PUBLIC PLANNING SUBMISSION: AMENDED DEVELOPMENT OBJECTION

Application: State Significant Development – 138 Maroubra Road (SSD-81426710)

Perspective: Surrounding Community Members & Adjoining Residential Neighbors

DRAWN BY	SCALE	SHEET SIZE	PRINT DATE
Author	1 : 500	A1	18/09/2025
DESCRIPTION			5:17:14 PM
SHADOW DIAGRAM PLANS			
SHEET 1			
PROJECT No	DRAWING No	REVISION	
21_435	DA8.300	I

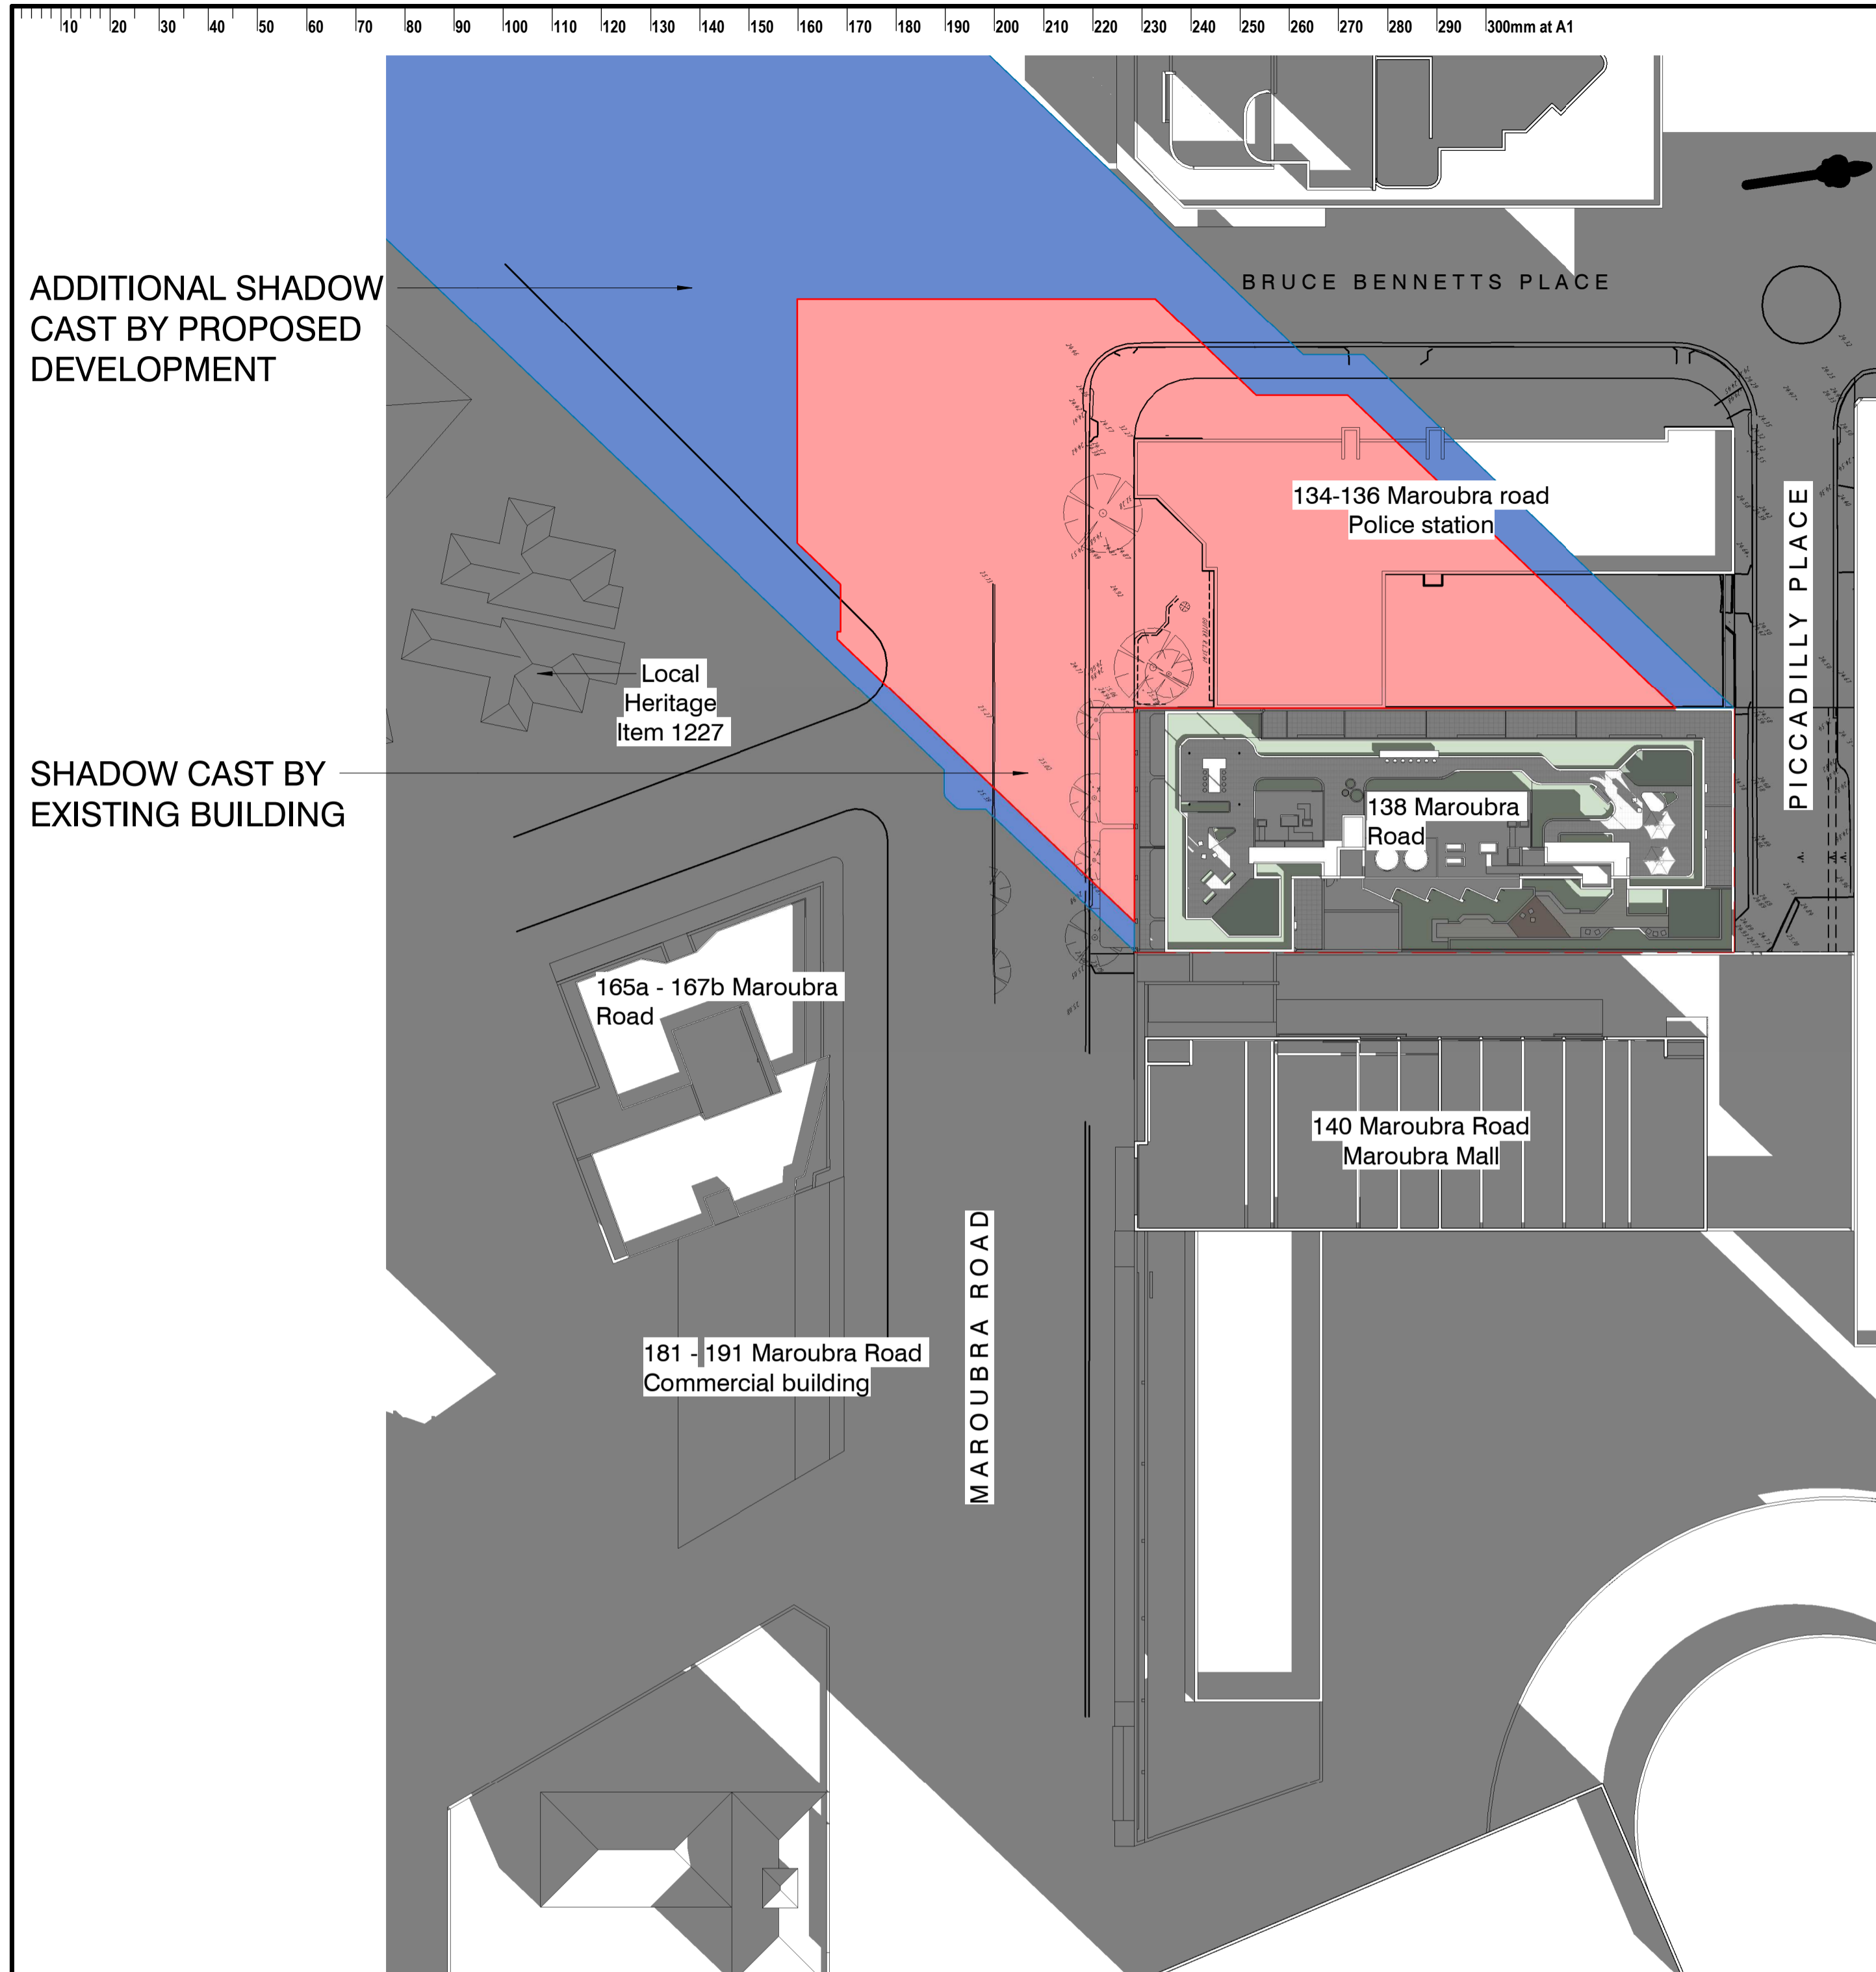
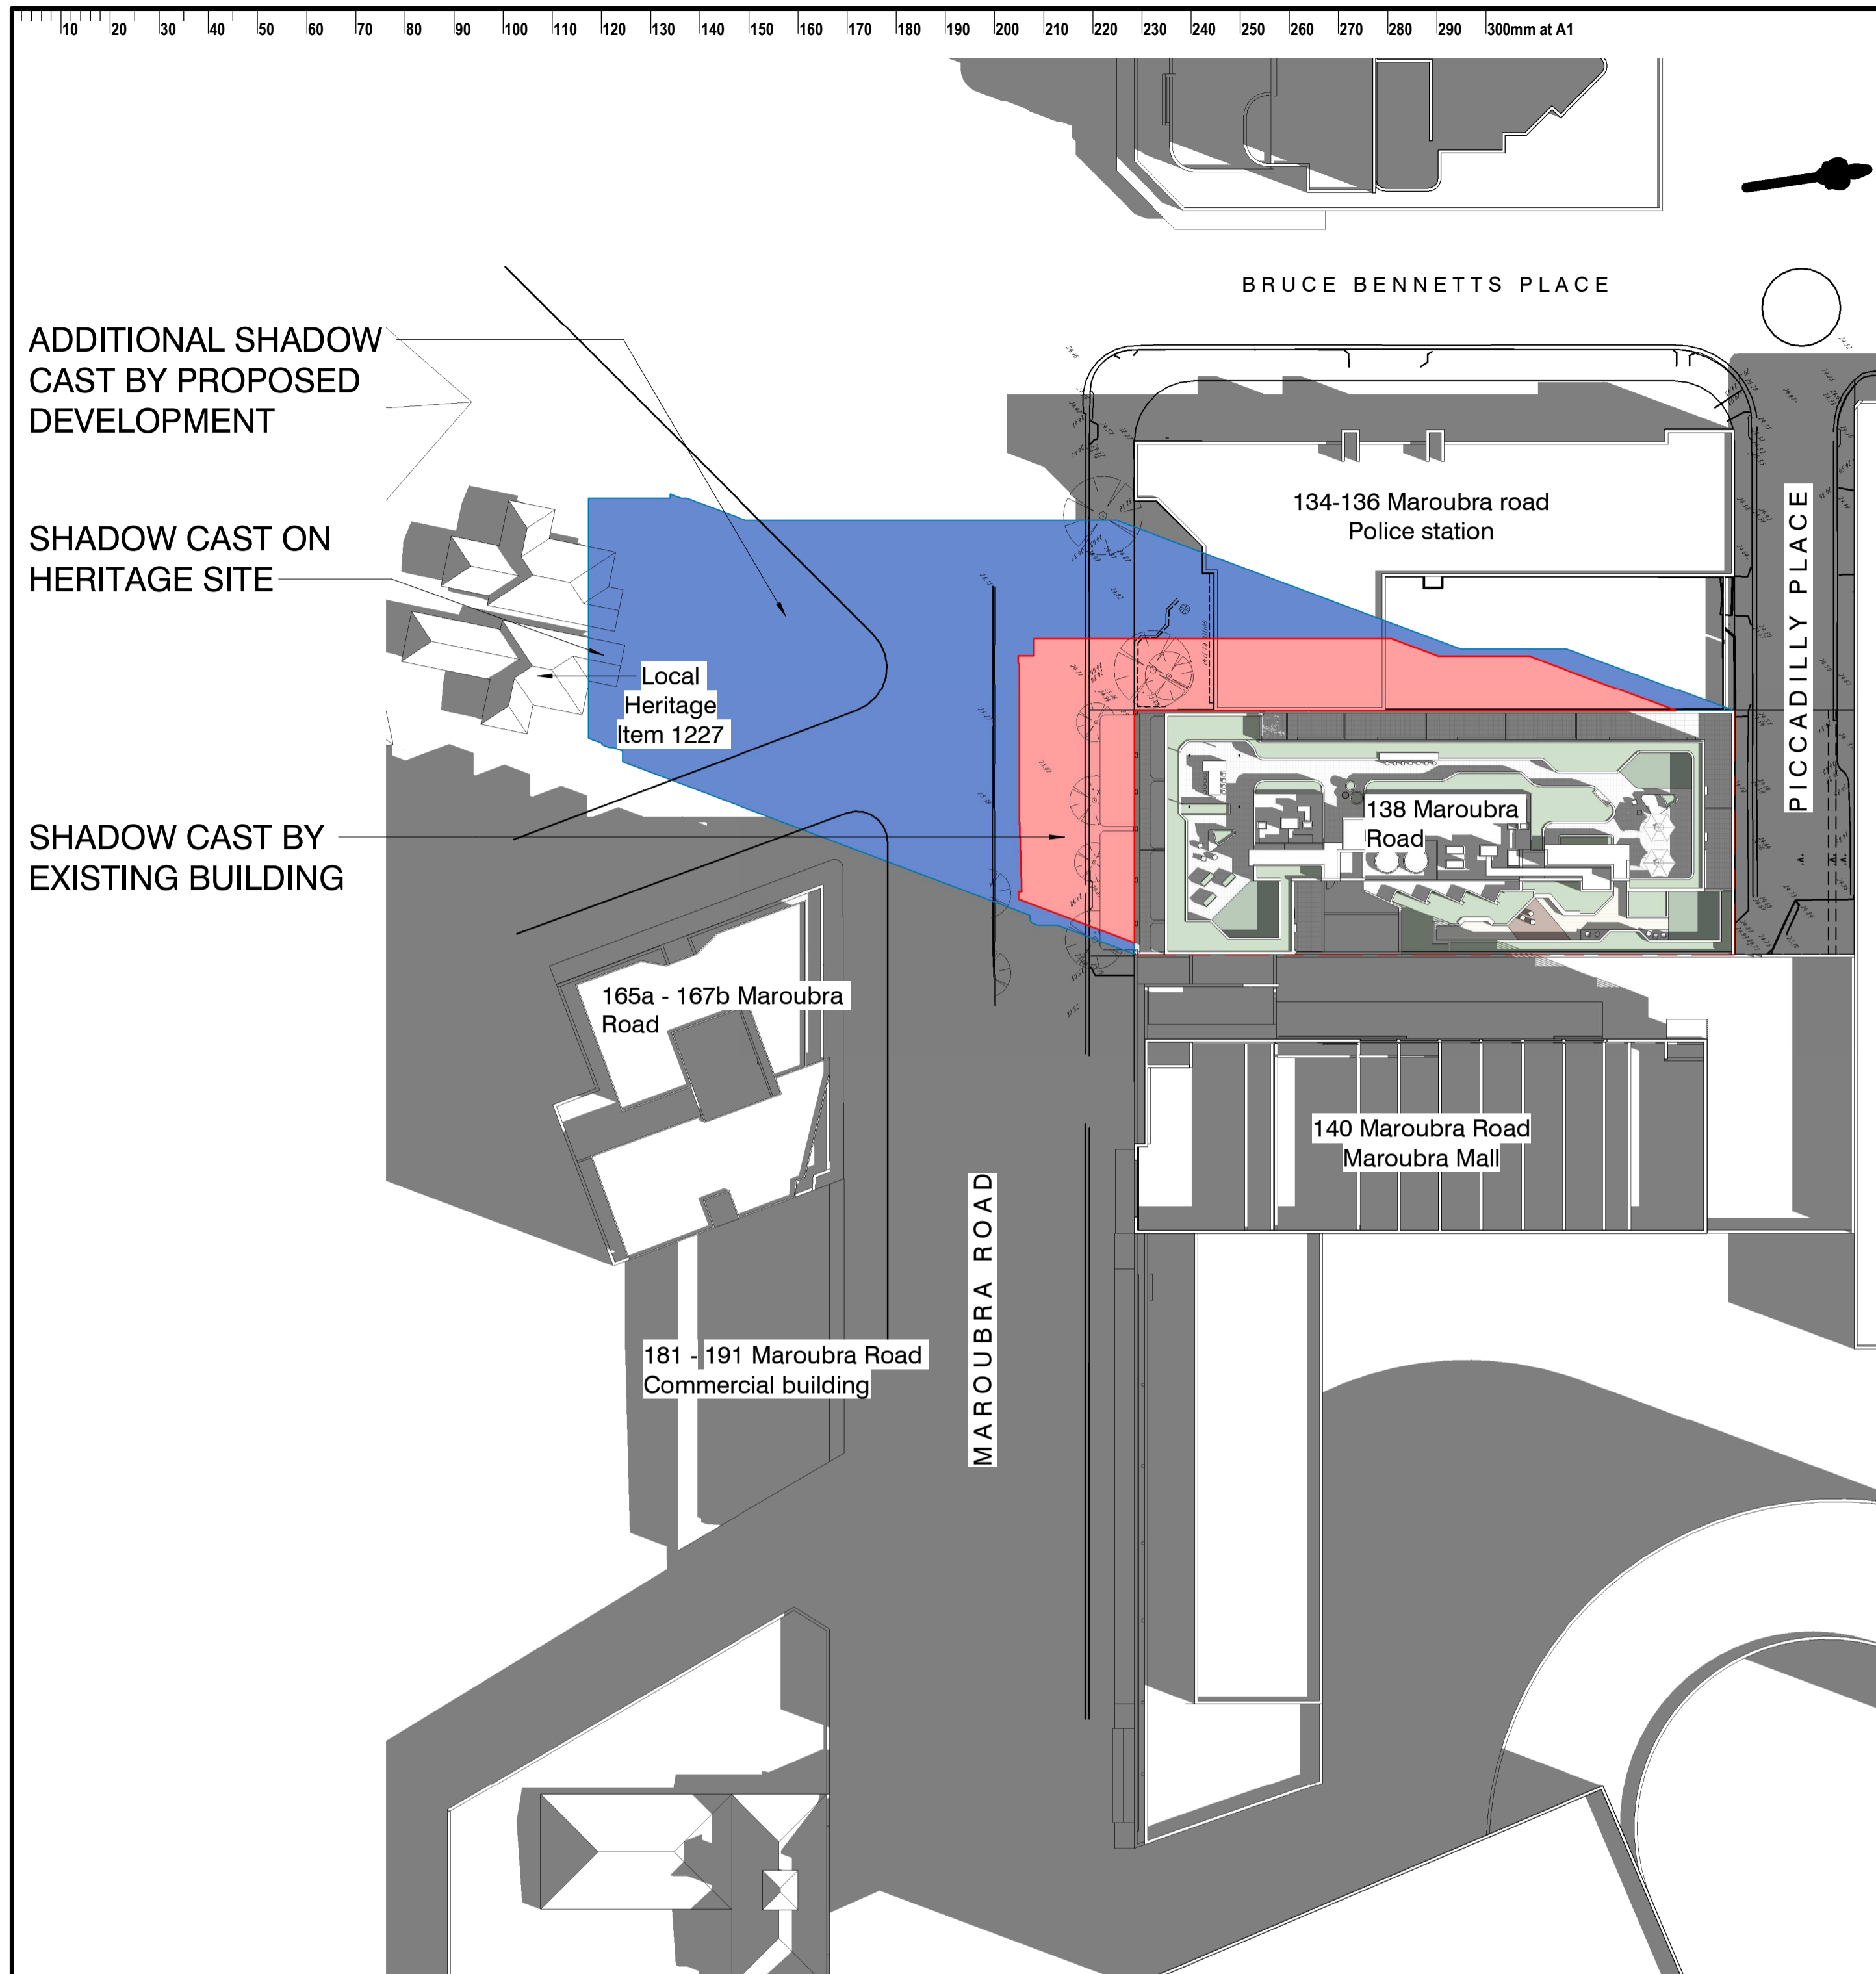
Afternoon Solar Deprivation and Extreme Microclimatic Shadowing on Adjoining Homes

The developer's updated shadow modeling relies on broad regional averages under the Apartment Design Guide (ADG), ignoring the direct microclimatic reality of neighboring properties. Constructing a deep, unarticulated 10-storey concrete envelope right to the boundary line completely blocks essential afternoon daylight.

Natural light is a crucial component of local living standards and natural apartment warmth. Depriving surrounding homes of afternoon sunlight degrades the well-being of neighboring residents. This impact is disproportionately borne by the high concentration of less-mobile senior citizens living in the adjacent building who stay indoors and depend heavily on natural sunlight for physical health and daily warmth.
